**Re: Lot 5 Block 3 Volcano Cliffs SAD 228
6320 Camino Alto
Request Permanent C.O. – Not Accepted
Engineer's Stamp dated: 1-31-17 (D10D003R5)
Certification dated: None**

Based on the Certification received 7/26/2017, the site cannot be accepted for release of Certificate of Occupancy by Hydrology until the following comment is addressed.

ENGINEER'S SEAL  12/27/16 DAVID SOULE P.E. #14522	6320 CAMINO ALTO	DRAWN BY WCMJ
	GRADING AND DRAINAGE PLAN	DATE 12-27-16
	 Rio Grande Engineering 1806 CENTRAL AVENUE SE SUITE 201 ALBUQUERQUE, NM 87106 (505) 872-0888	21647-LAYOUT-12-27-16
		SHEET # JOB # 21647

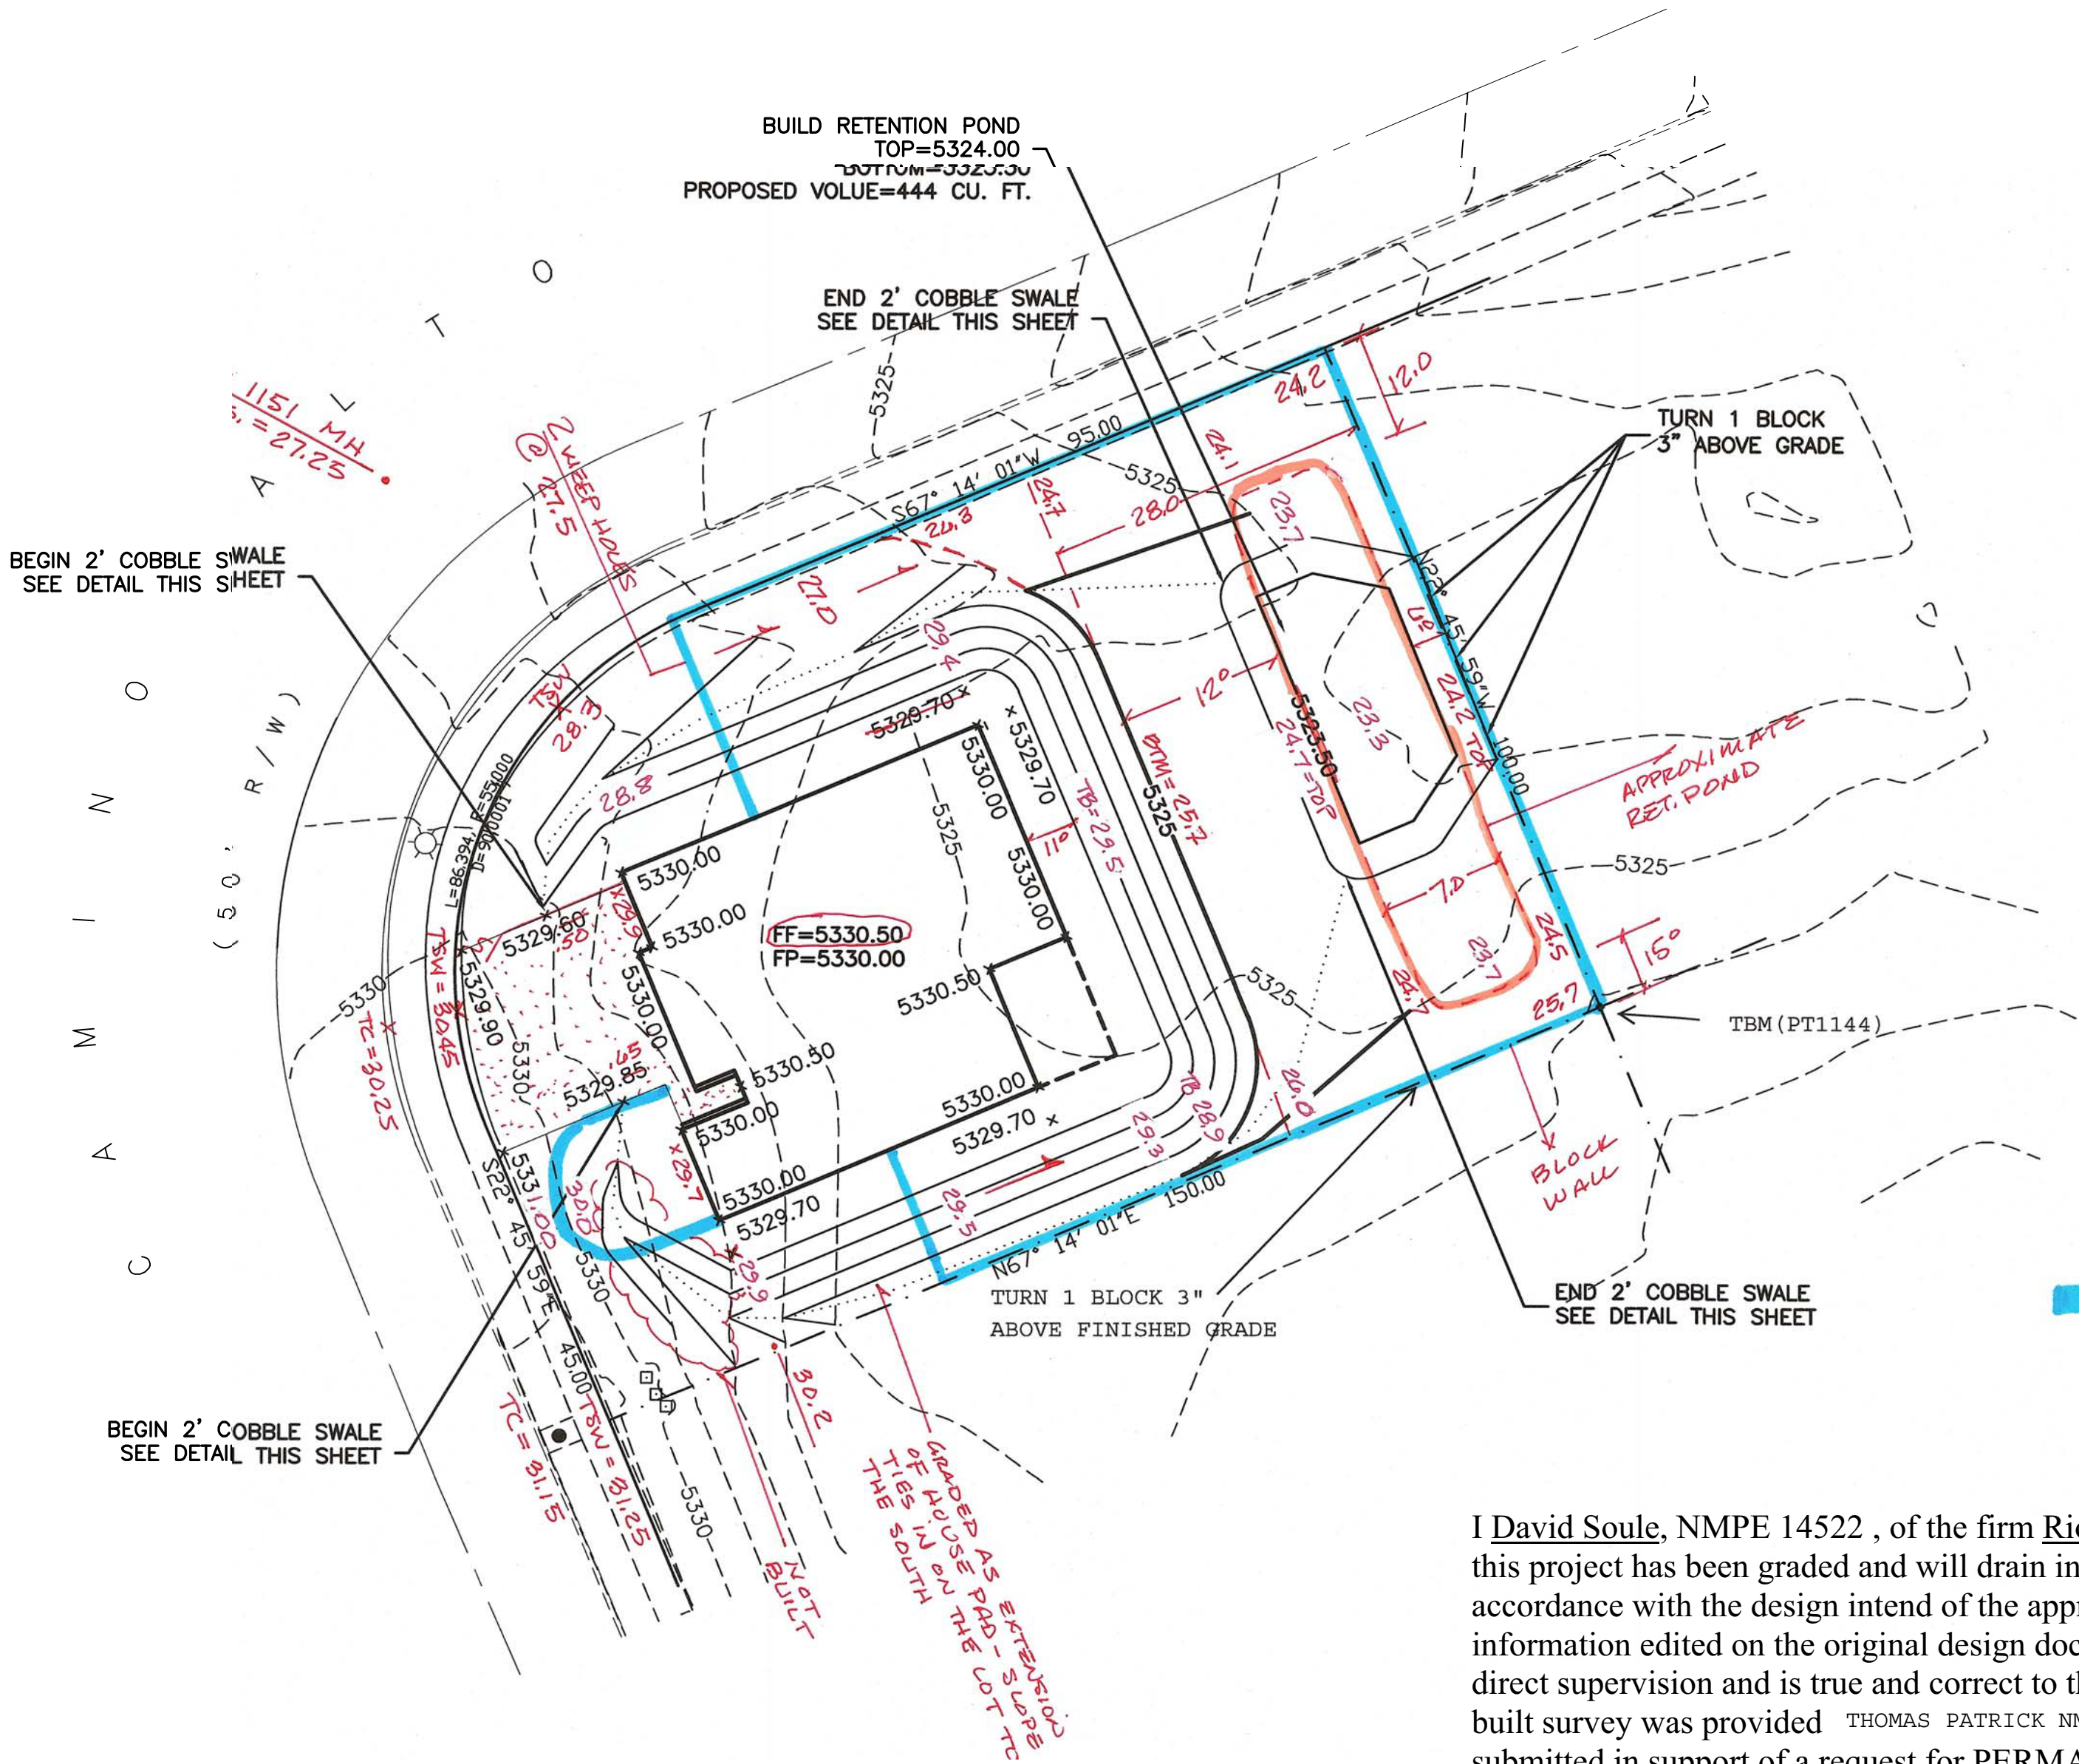
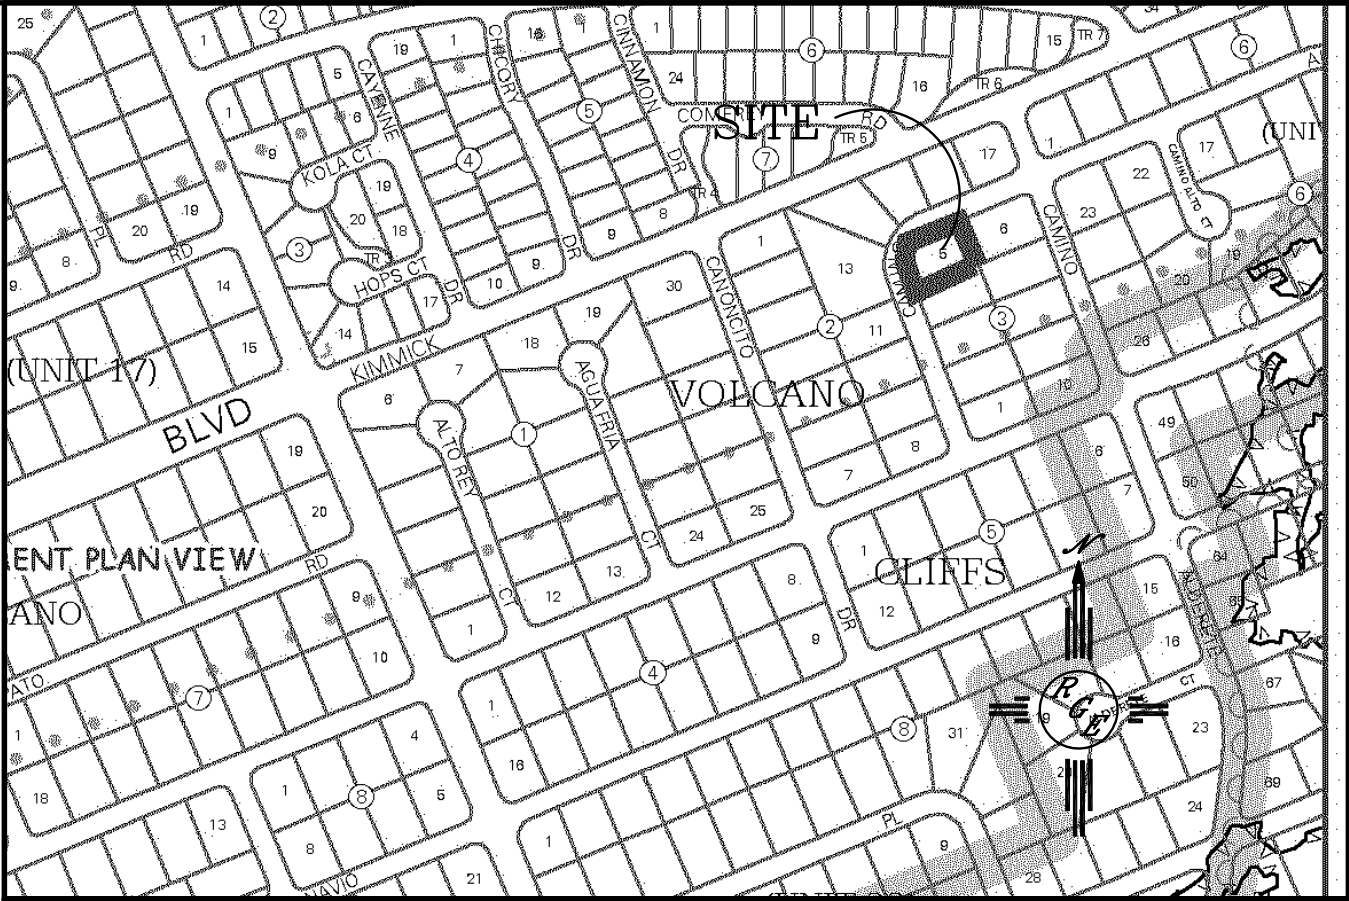
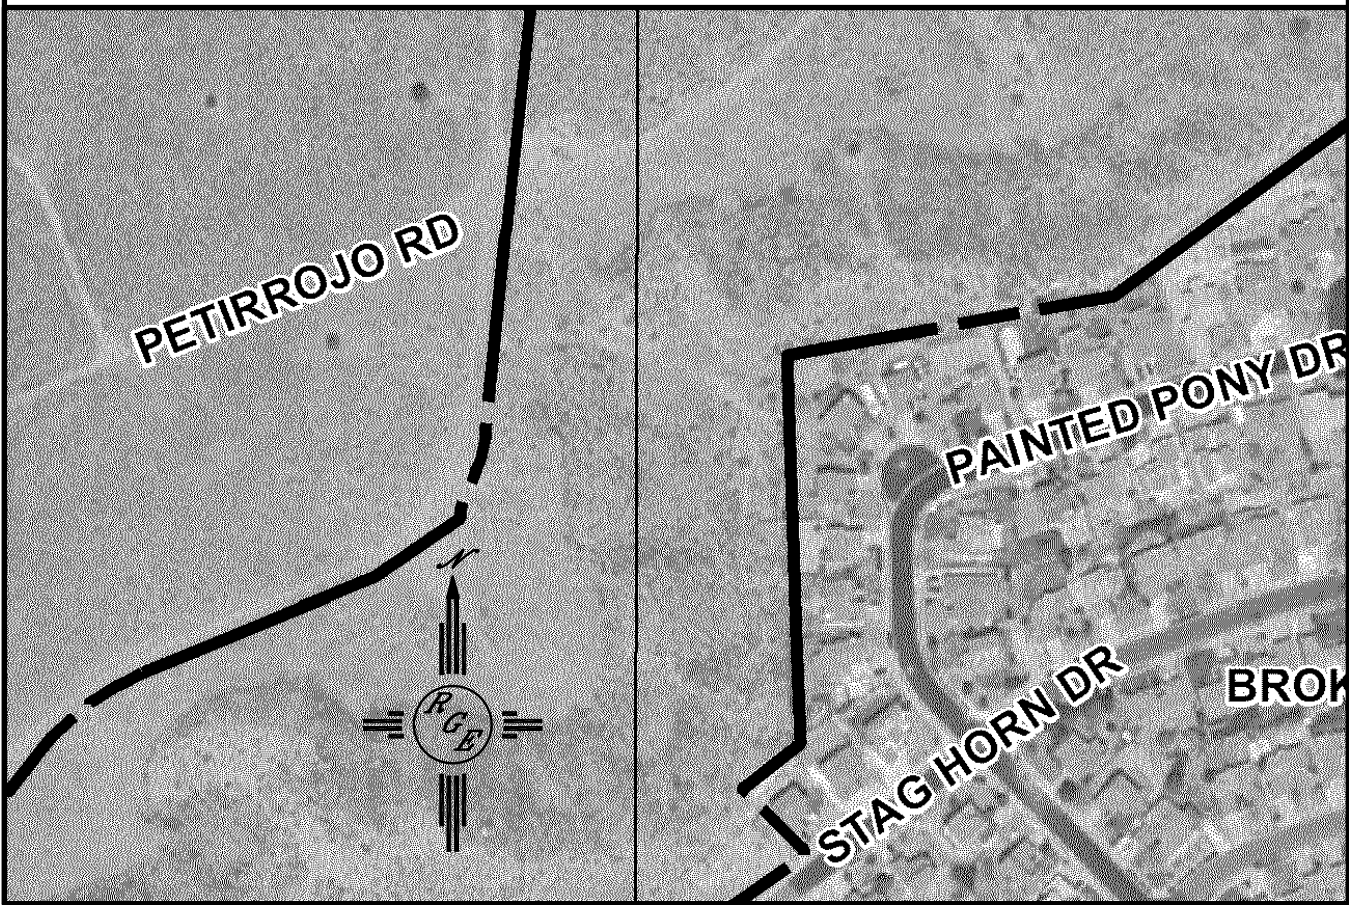
- Provide the language for the Certificate of Occupancy with your signature and date on the plan dated 1/31/17.
